Rustington Parish Council
Mrs C Ward
34 Woodlands Avenue
Rustington
West Sussex
BN16 3HB

Change of use of currently vacant former A1 (Shops) ground floor premises to a mixed A3/A5 (Restaurants & Cafe & Hot Food Takeaway) use, incorporating the erection of a single storey rear extension, replacement shopfront & associated plant & extraction equipment

4 Broadmark Parade Broadmark Lane Rustington

My Council has considered this application and wishes to object to it on the following grounds:-

PROJECT:	Rustington BN16 2NE	
CLIENT:	K & Z	
DRAWING:	General Arrangement of HVAC Installations Plan & Side Elevation	
SCALE:	1:25@A1	DRAWN: N.O.D. DATE: 01/02/19
JOB No:	00000	CHECKED: DATE:
DRAWING No:	0000/M/101 REV B

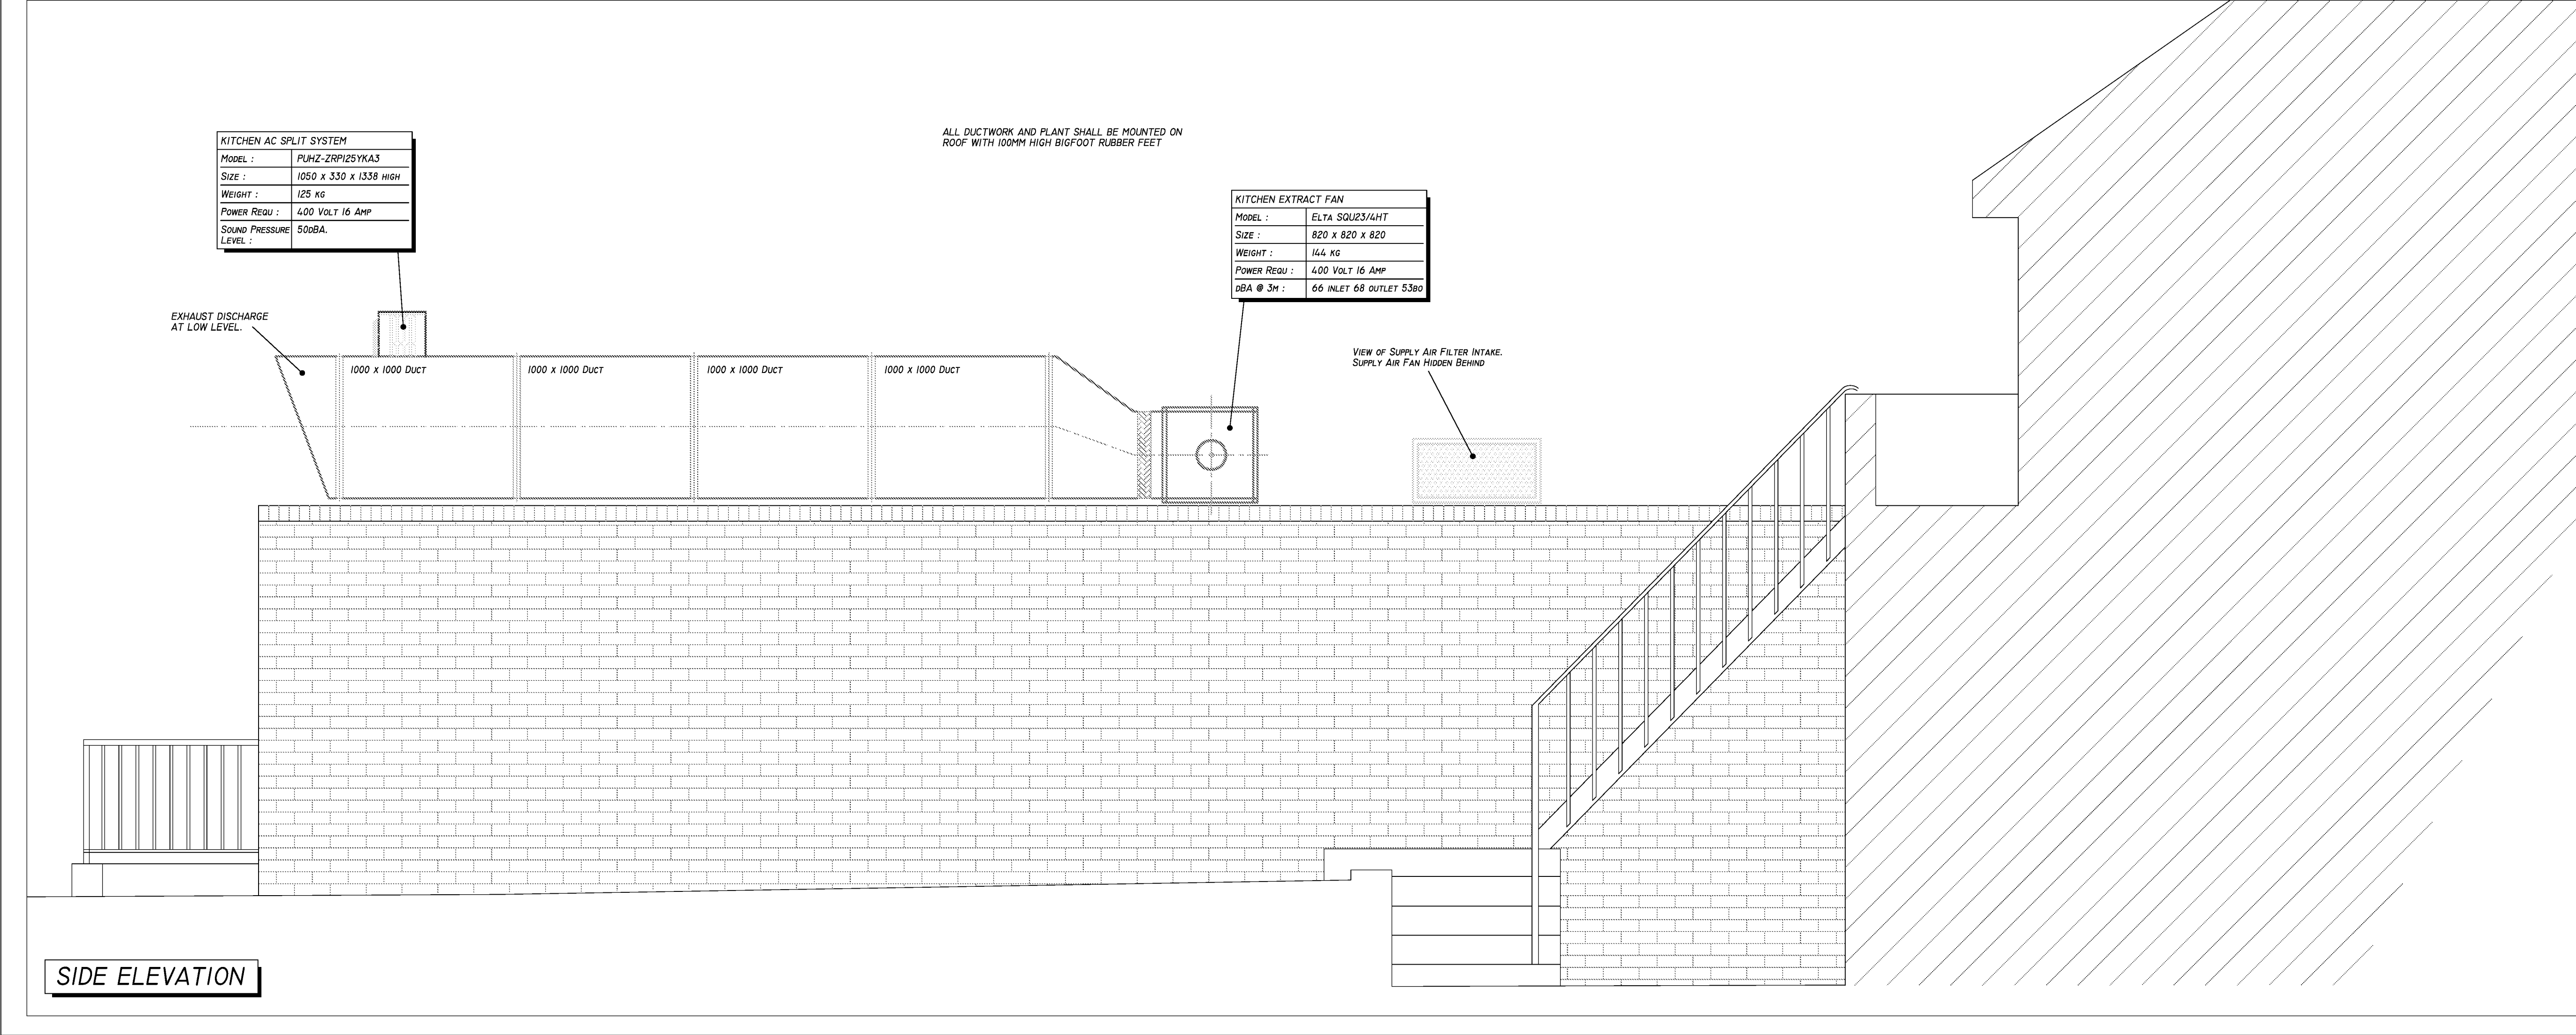
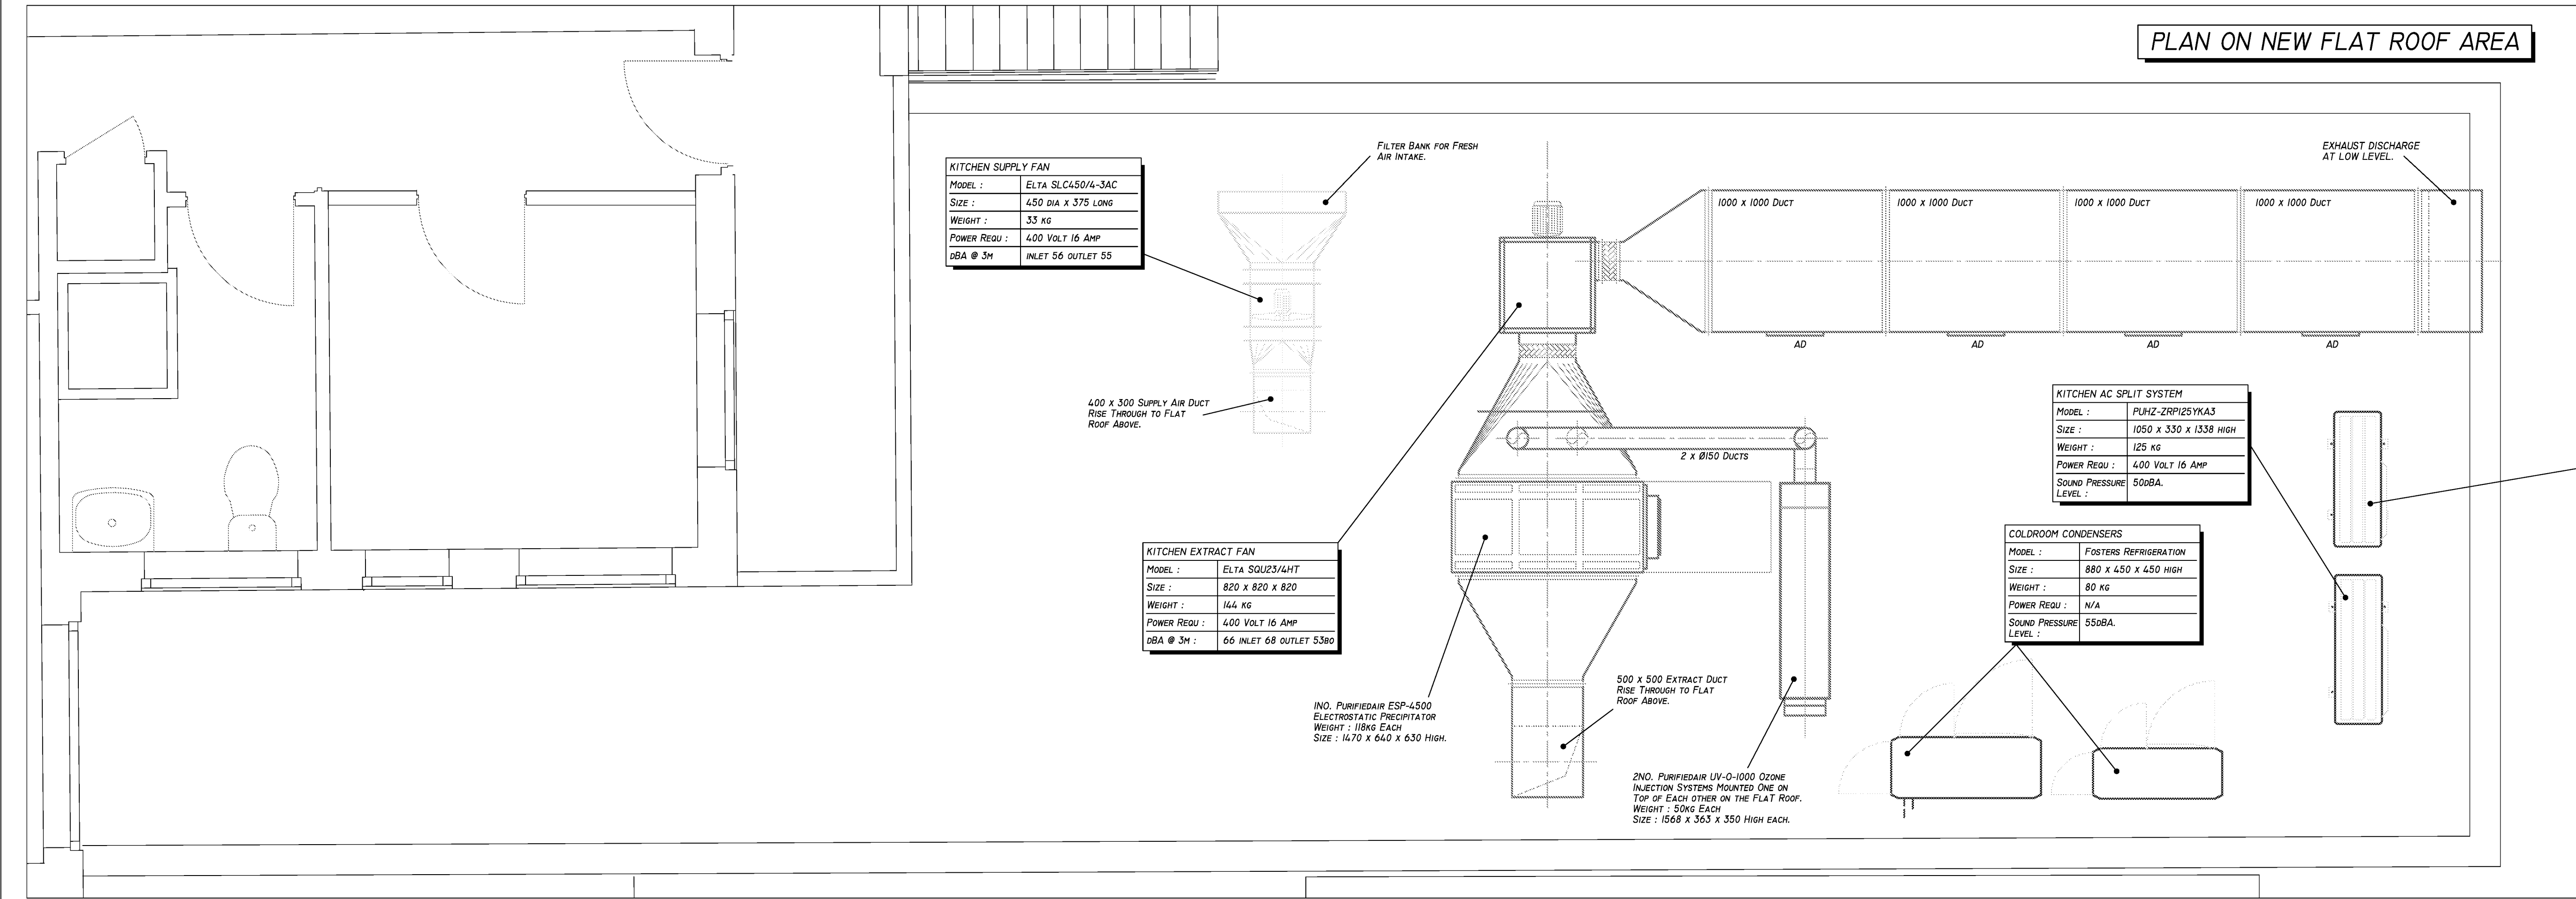
(ii) The proposal to install extraction equipment on the roof of the proposed extension, in close proximity to residential properties, by reason of its mass, noise emission levels and fumes, in particular, would most certainly be detrimental, and adversely affect, the quiet enjoyment of the occupiers of these properties
